Final Drainage Report_V1.pdf Markup Summary

Cornerstone Estates

PROPOSED DRAINAGE MAP

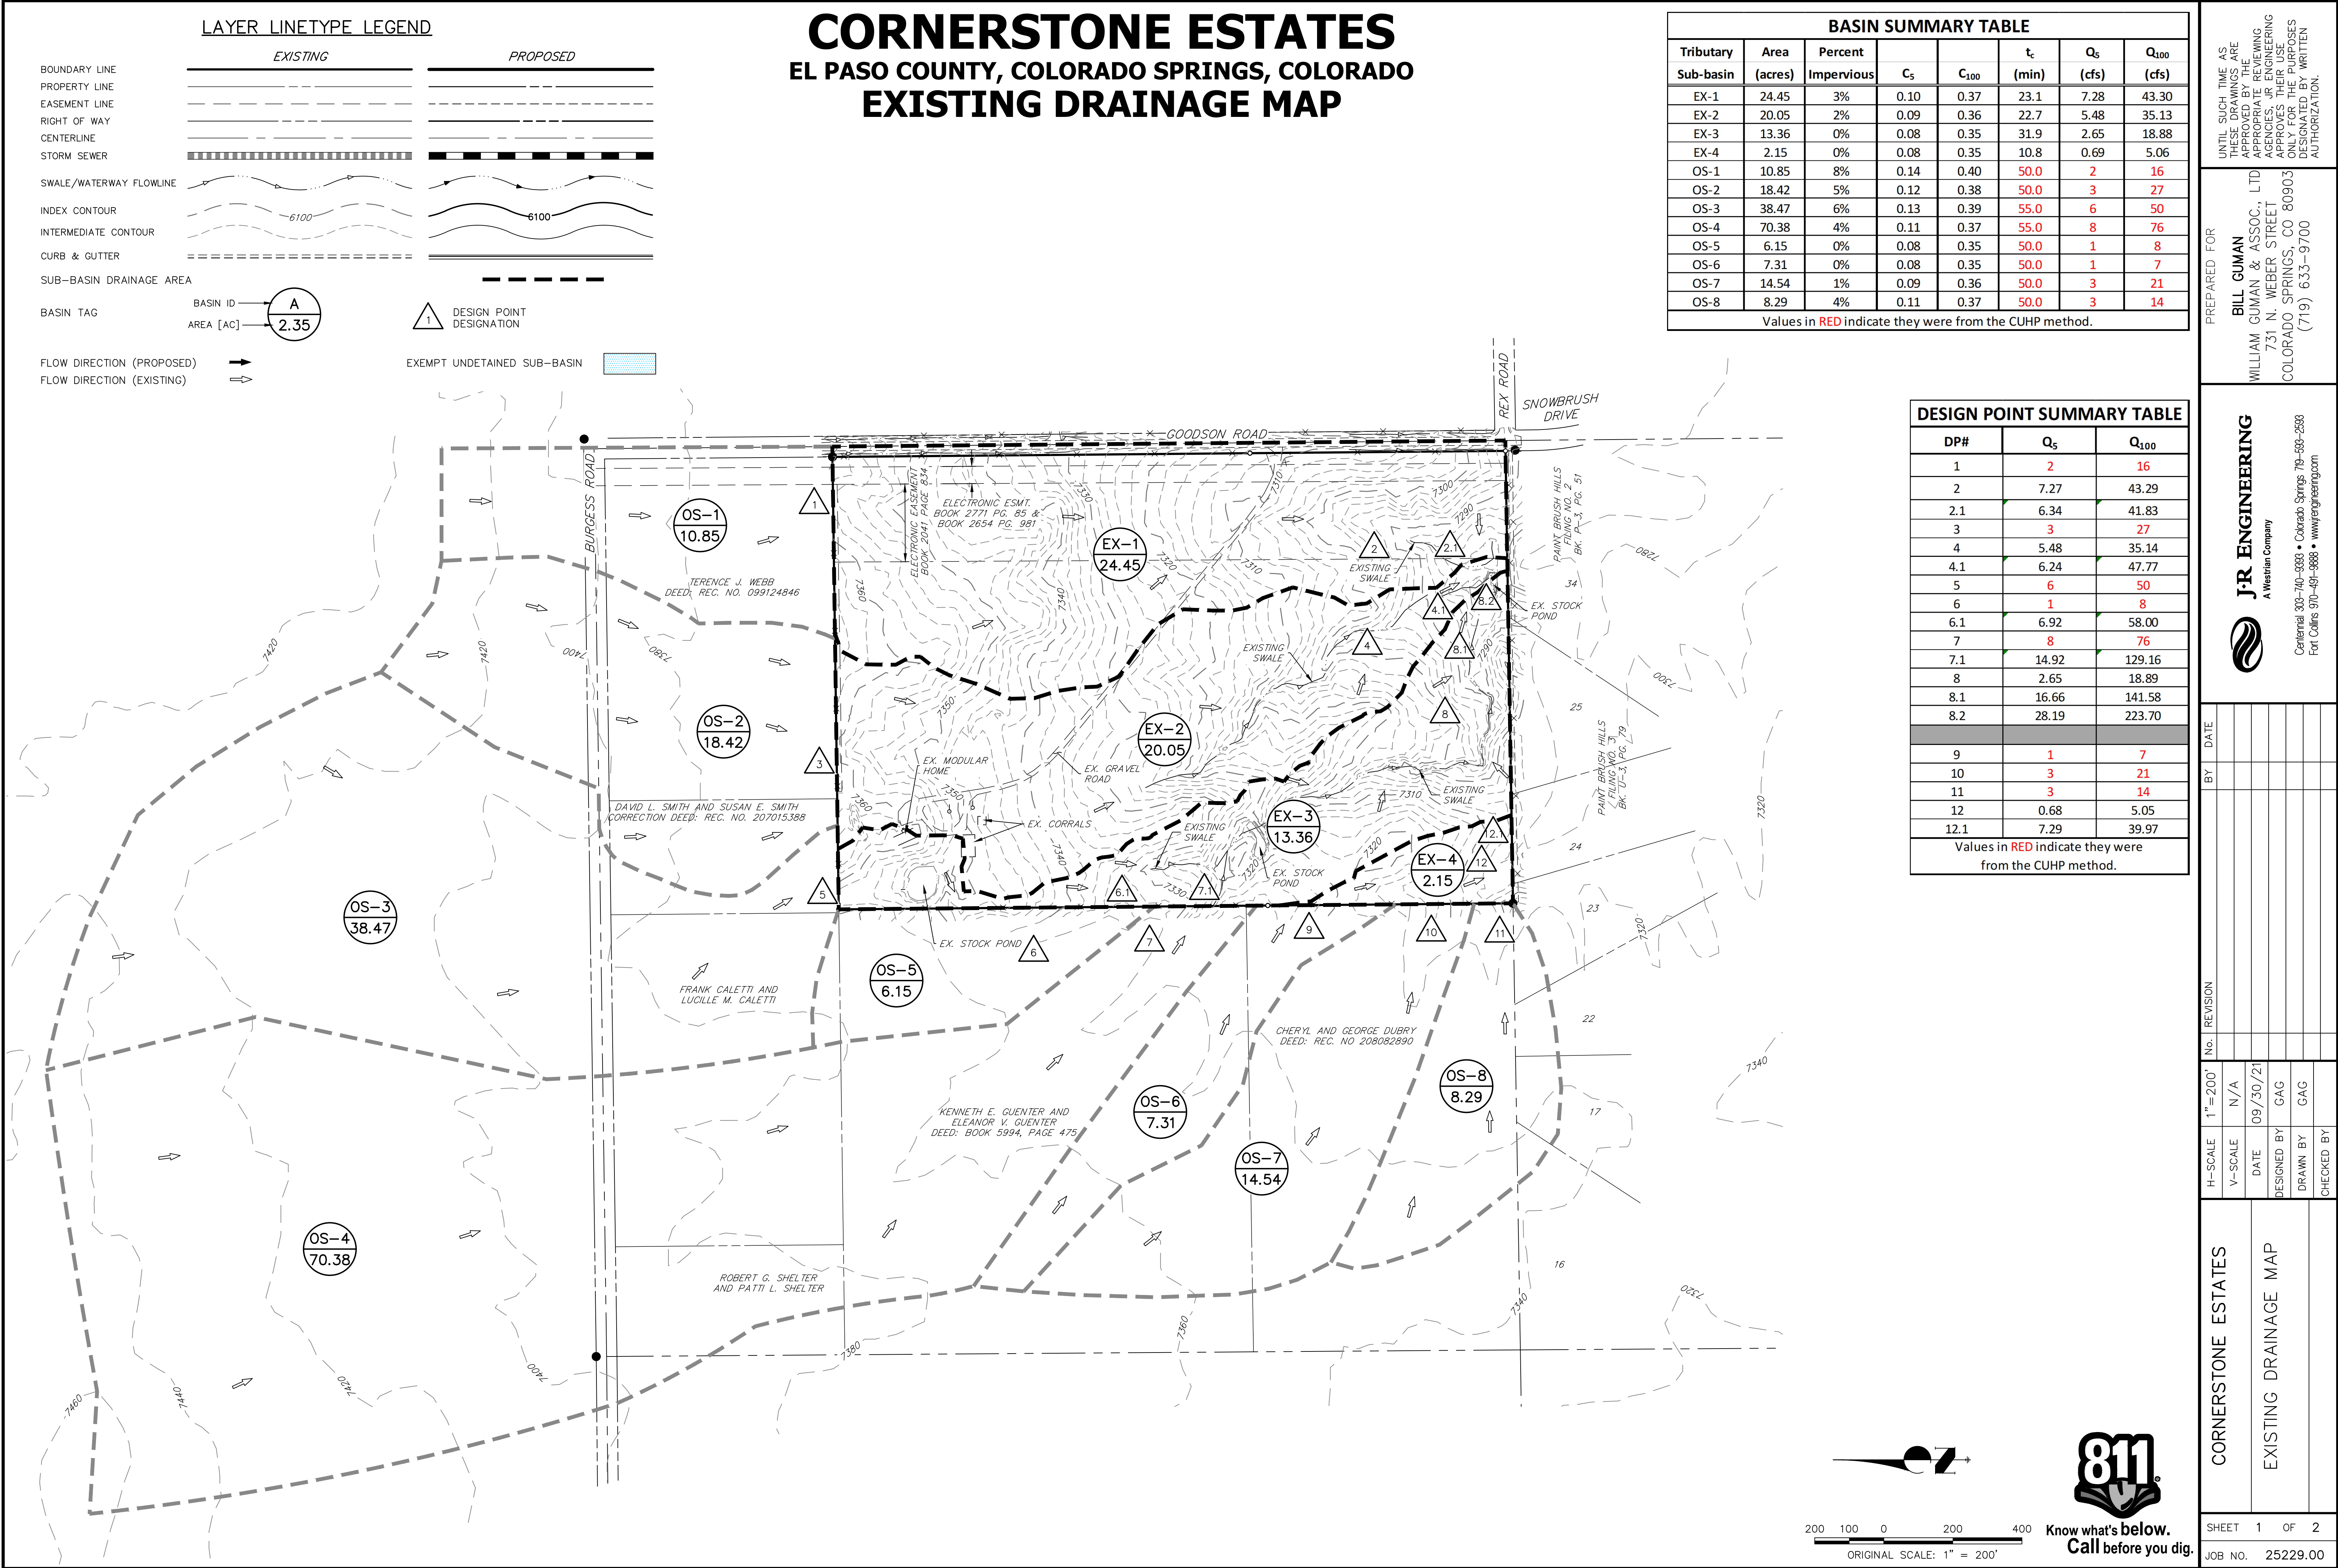
Note: This is entirety of project. Basins H, OS-6 thru 8 do not reach pond

Check impervious percentage based on comment on hydrology spreadsheet
